Our Ref: BN/54/21/DOC

Approval of details reserved by condition imposed under ref BN/50/20/PL relating to Condition Nos 5 - mitigation method statement, 6 - archaeology, 7 - piling risk assessment & method statement, 8 - Construction & Environmental Management Plan, 9 - foul drainage, 10 - surface water drainage, 11 - maintenance & management of surface water drainage, 13 - pre-commencement site meeting, 15 - odour assessment or evidence that livery has ceased, 16 - soil resource plan, 17 - landscaping, 18 - screen walls & fences, 19 - elevation details of 2 proposed communal bin stores and 20 - colour schedule of materials & finishes.

Land Rear Of 1 Northfields Cottages Fontwell Avenue Eastergate PO20 3RX

Arun District Council have decided to **REFUSE details reserved by condition for the following reasons:**

Materials schedule

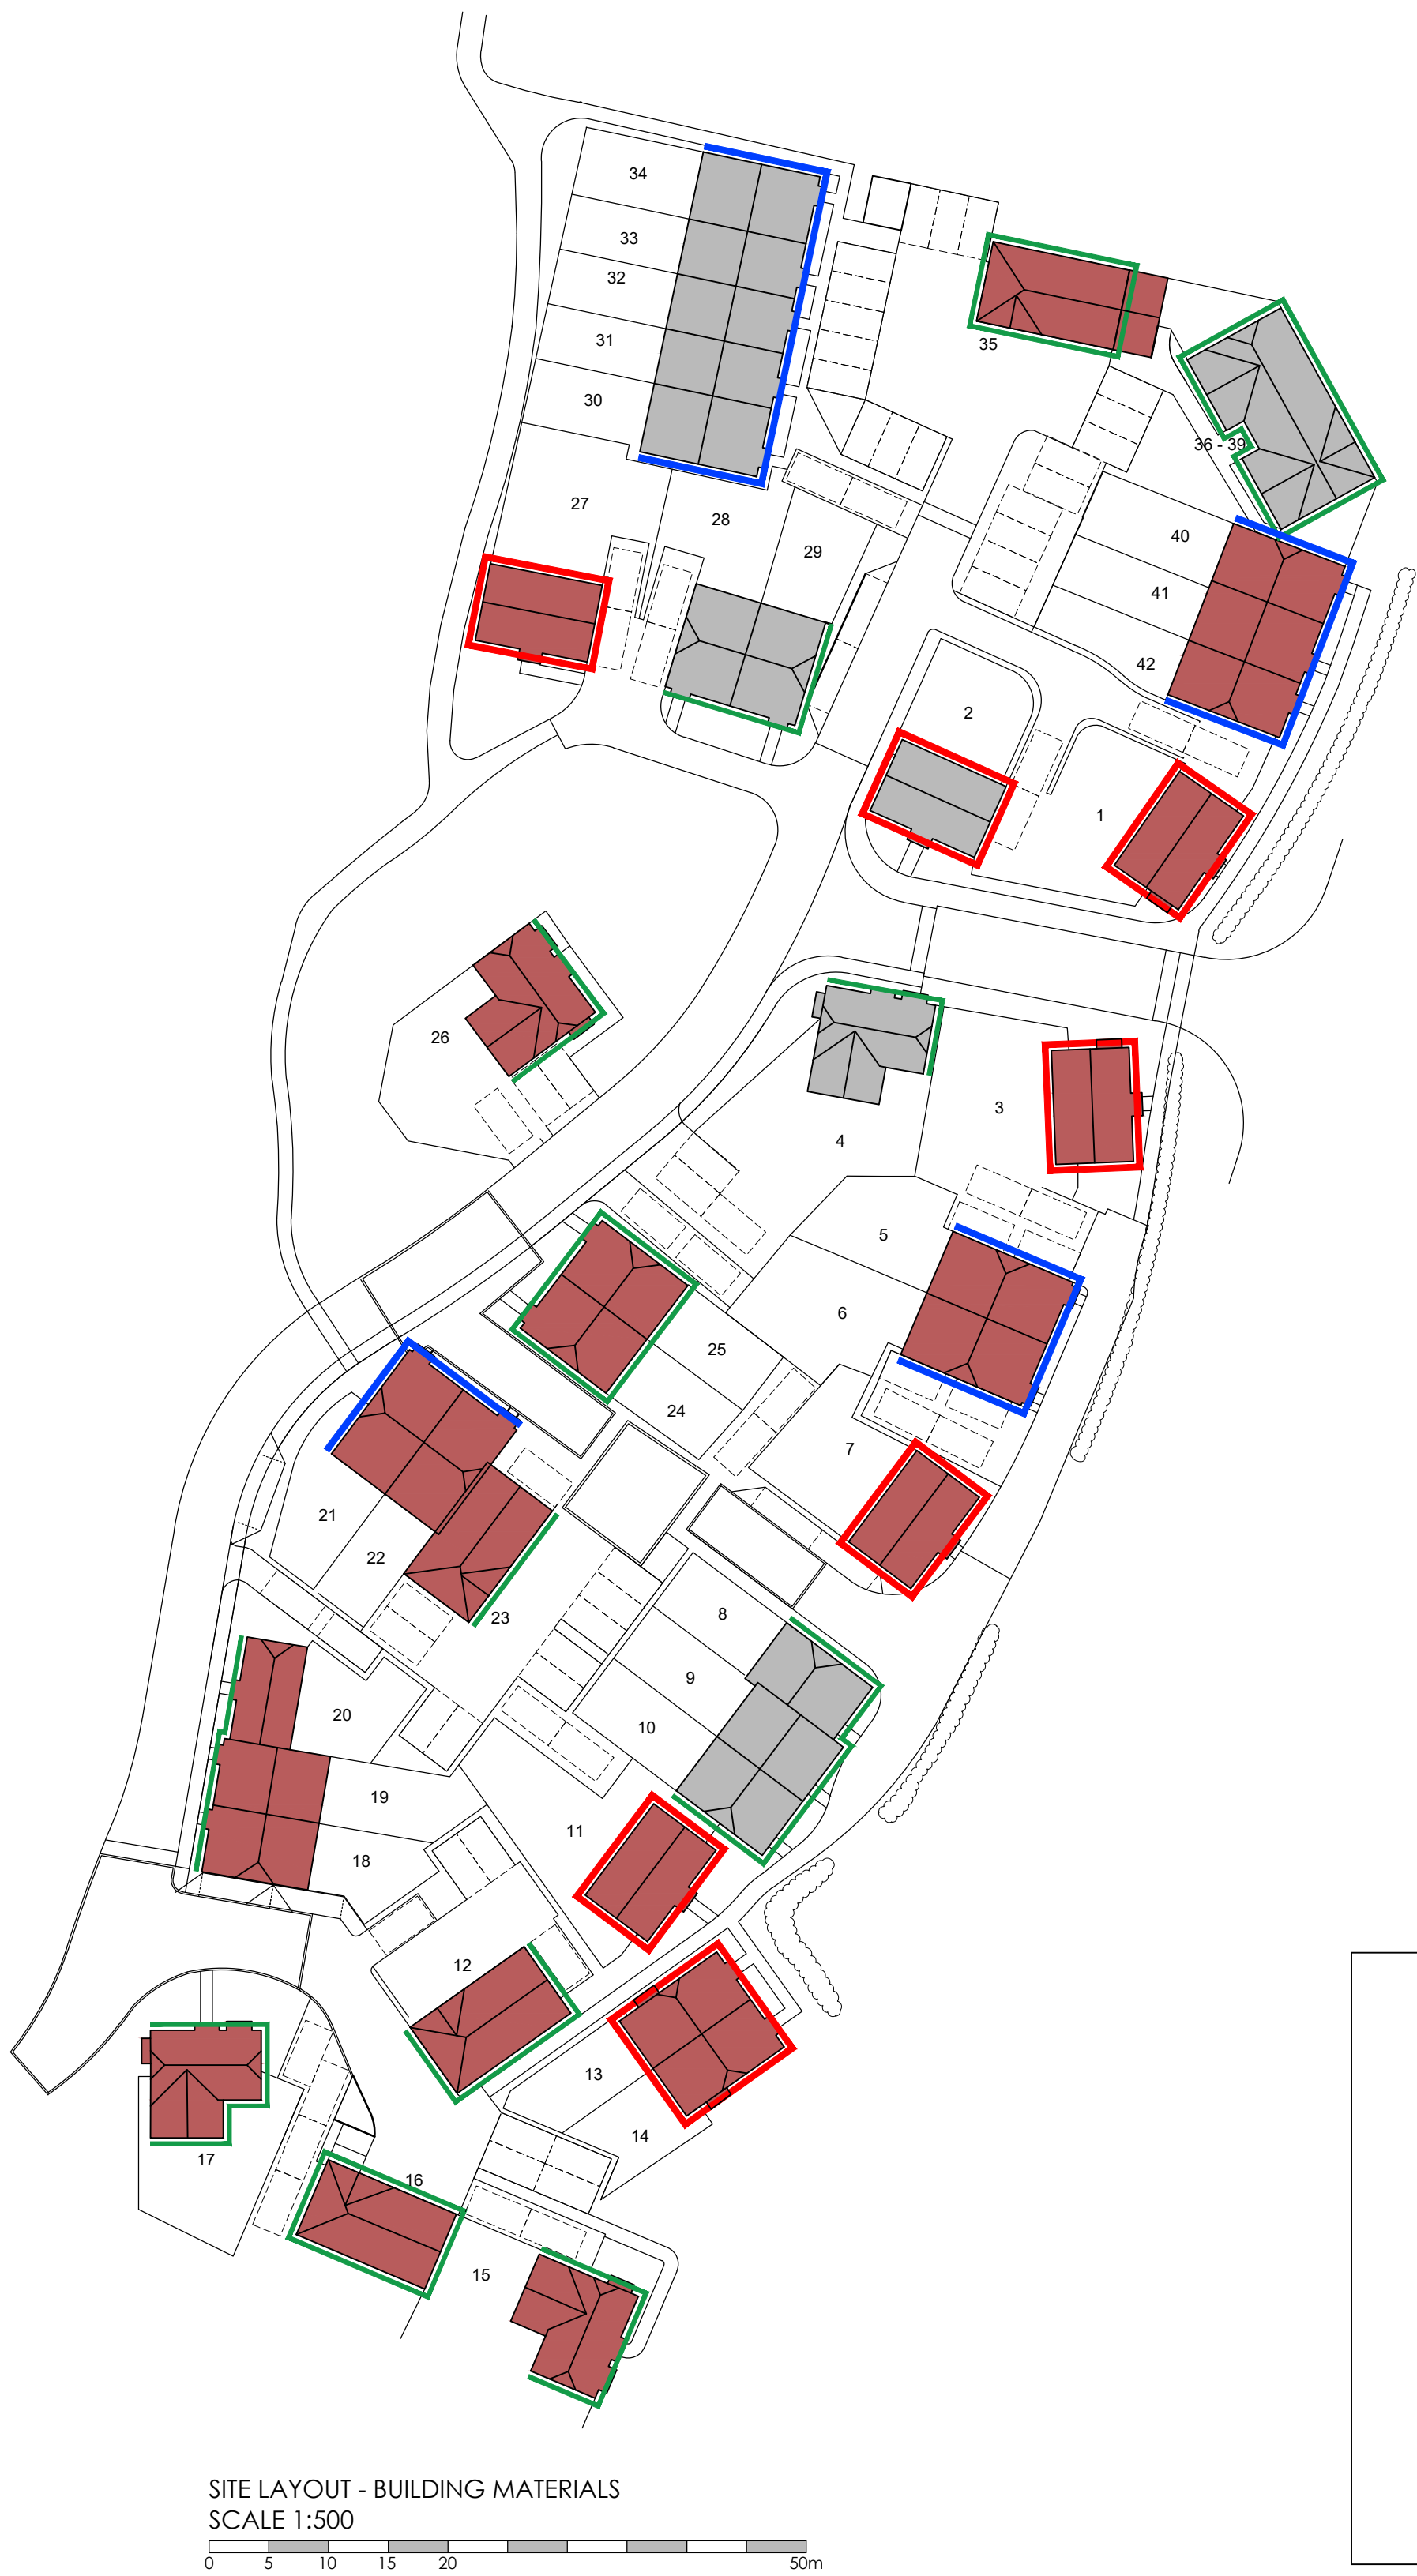
The condition requires a colour schedule of all materials and finishes to be used for external walls and roofs. You have provided a plan which provides a material reference for each different plot. However, these references (B1, B2, B3, W1, RT1, RT2) do not identify the type/appearance of the actual materials and there is no separate schedule identifying these. As such, it is not possible to discharge the condition at the current time.
